**RESPONSES TO EXAMINING AUTHORITY'S
QUESTIONS 07/07/2025 (ExQ5)
ON BEHALF OF THE
HISTORIC BUILDINGS AND MONUMENTS COMMISSION FOR ENGLAND
(HISTORIC ENGLAND)**

**Interested Party Ref No:
20050154**

**Dogger Bank South Offshore Wind Farm Projects (Reference No.
EN010125)**

Plate 4-32 Indicative landscape mitigation plan

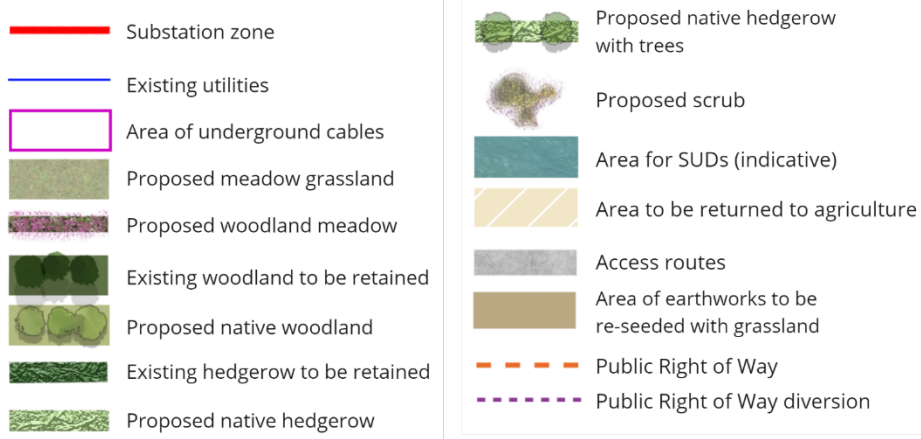
It remains our judgement that planting does not equate to screening, owing to its seasonal nature and susceptibility to disease and loss through wind action. Although the Applicants have submitted a revised scheme for a smaller footprint OCS site, we still consider that this is a large, physical intervention into the landscape and on the setting of the scheduled Gunsite. As a consequence we do not consider that there will be any substantive change between Years One and Ten of operation and maintain that the OCS will represent 'less than substantial harm' to the significance of the Butt Farm Gunsite. We acknowledge the outreach and public engagement as benefits secured by the Written Scheme of Investigation and leave the balance/weighing to the ExA.

We note that the final planting scheme will be approved post-consent and have welcomed the statement that we will be consulted as part of the Design Review Panel.
